CITY OF ALBUQUERQUE

October 17, 2013

**Re: 8801 Glendale Ave NE, Grading and Drainage Plan
Engineer's Stamp Date 10-8-13 (B20D021)**

CULVERT INLET DETAIL

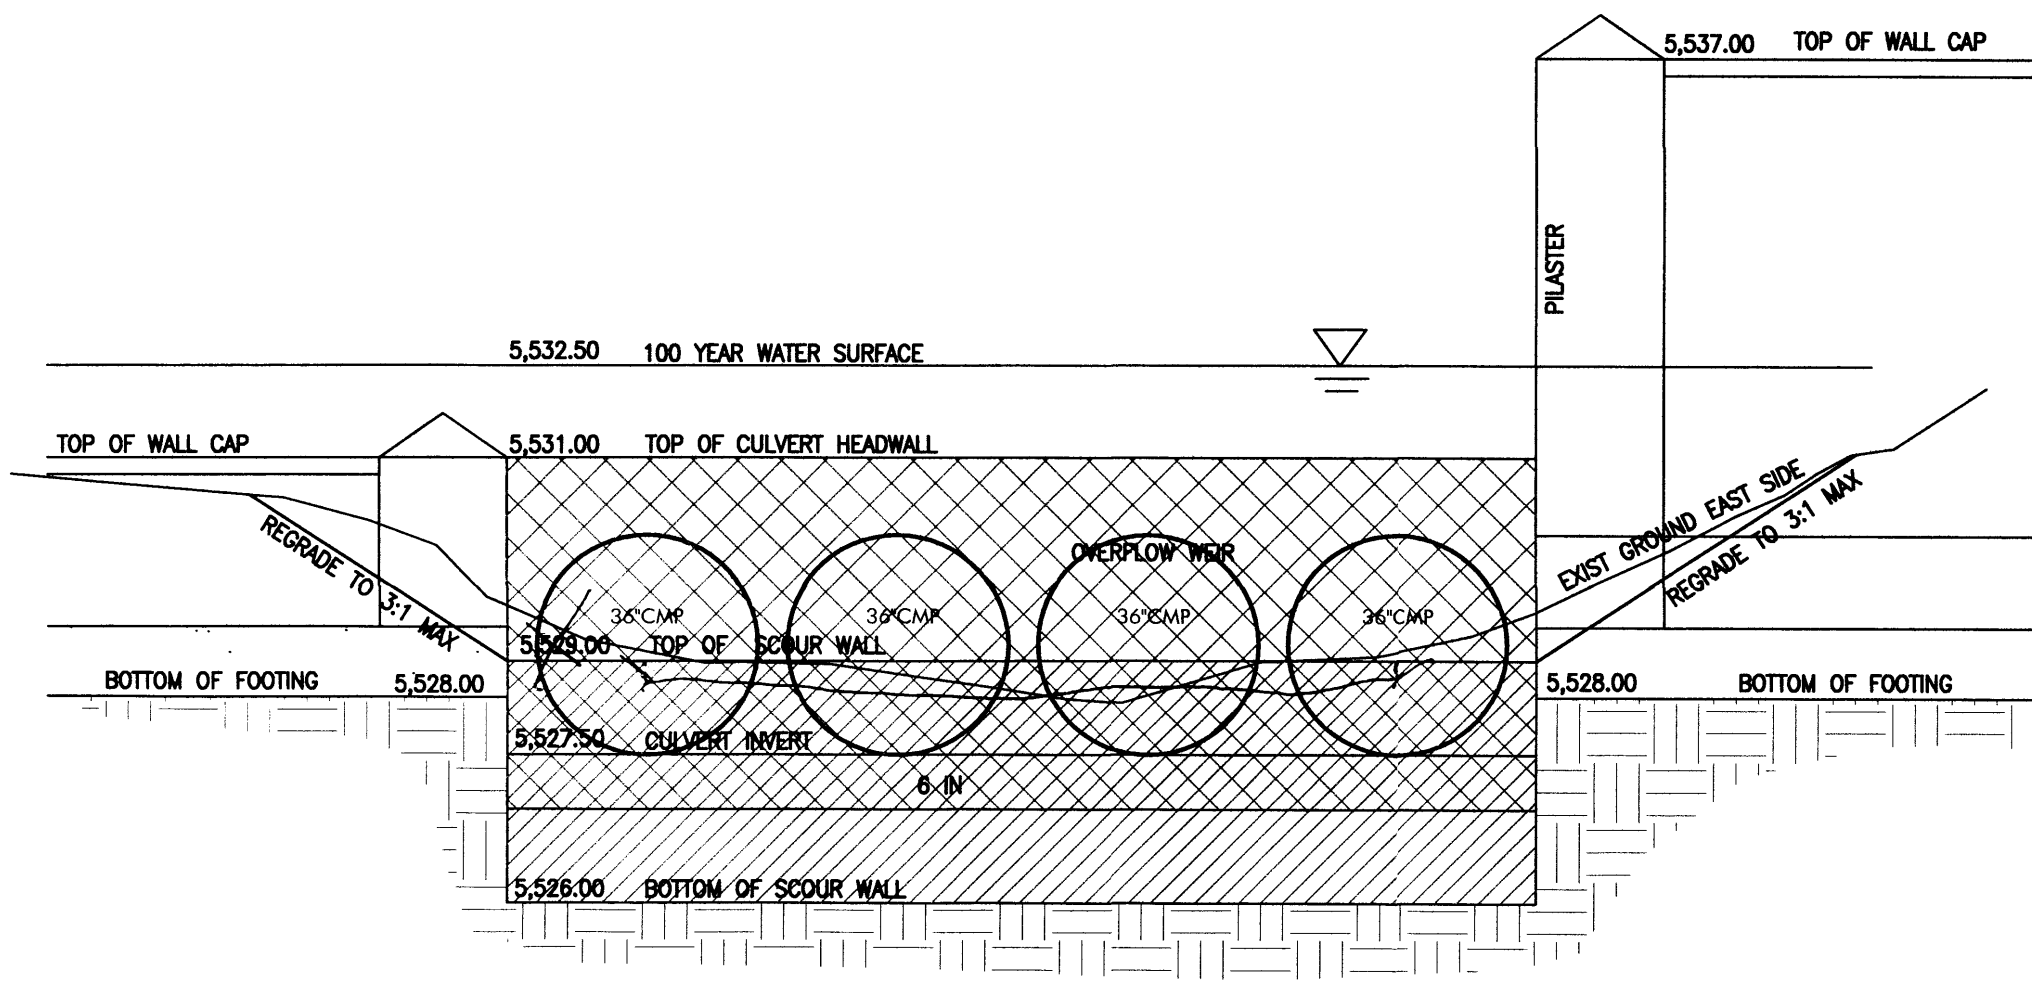
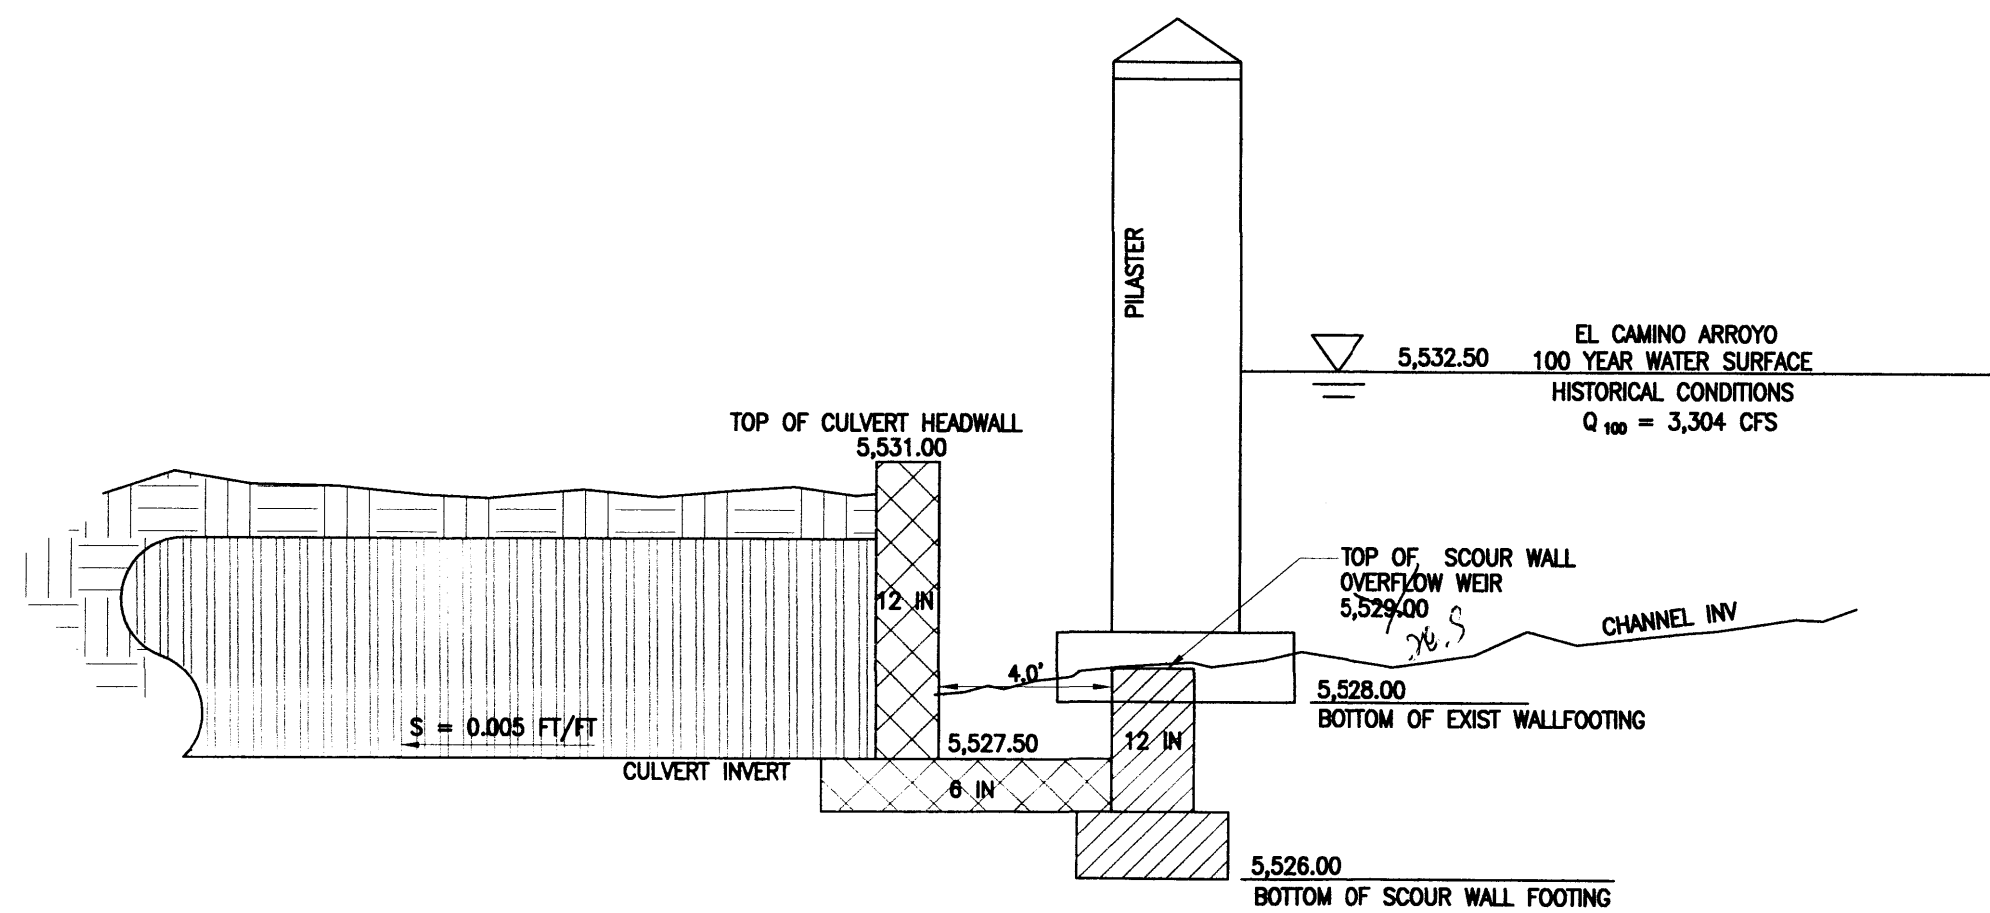
1. Per our meeting October 4th, the height of the inlet weir was discussed and the elevation of 28.5 was agreed to by all parties present. Parties present were, myself, Bryan Wolfe, Gary Padilla and you. The 28.5 elevation was agreed to because that was the predevelopment invert elevation of the arroyo. Why would you then submit a plan with an inlet weir elevation of 29?

If the reason for the 29 elevation is to protect the footers of the existing wall, it is acceptable to have the elevation of the inlet weir at 29 for a couple feet in from each footer, then cut a taper down to the agreed upon 28.5 elevation for the remainder of the inlet weir.

Revise Sheets C1 and C2 to reflect the above comment.

SECTION A-A

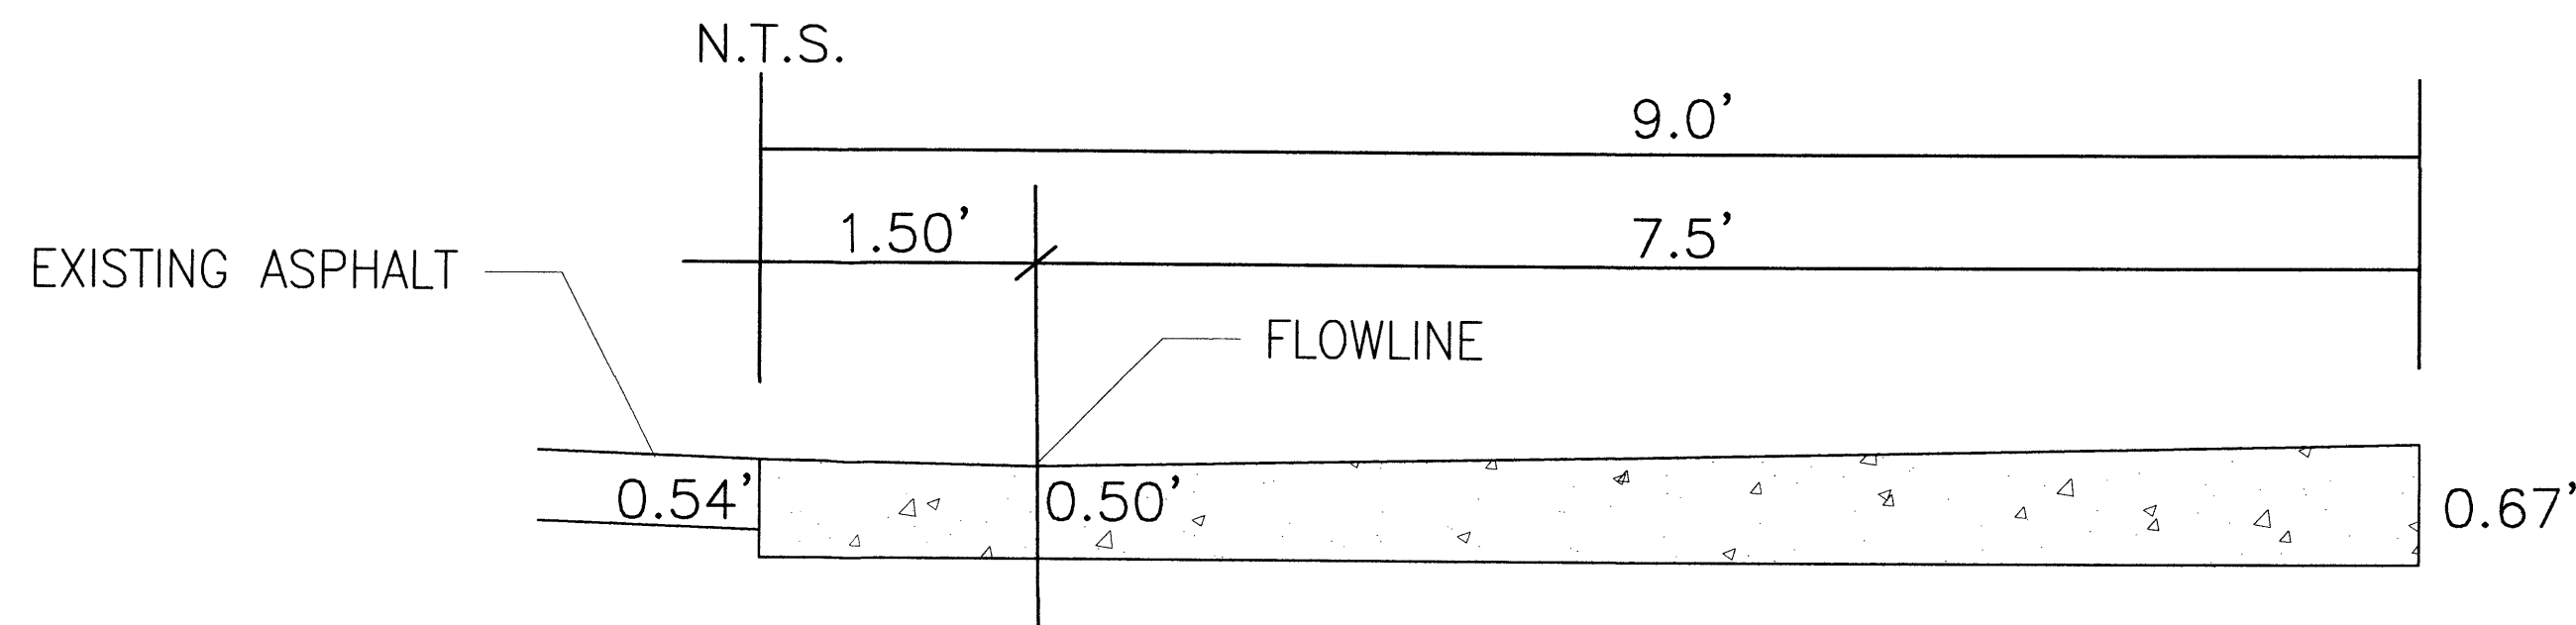
2. The following comment was provided in the letter dated October 7th, 2013 and was not addressed: The culvert headwall should be tied into the concrete below it so it doesn't fall over due to the load above it.

3. A similar condition exists for the headwall along Glendale Ave.
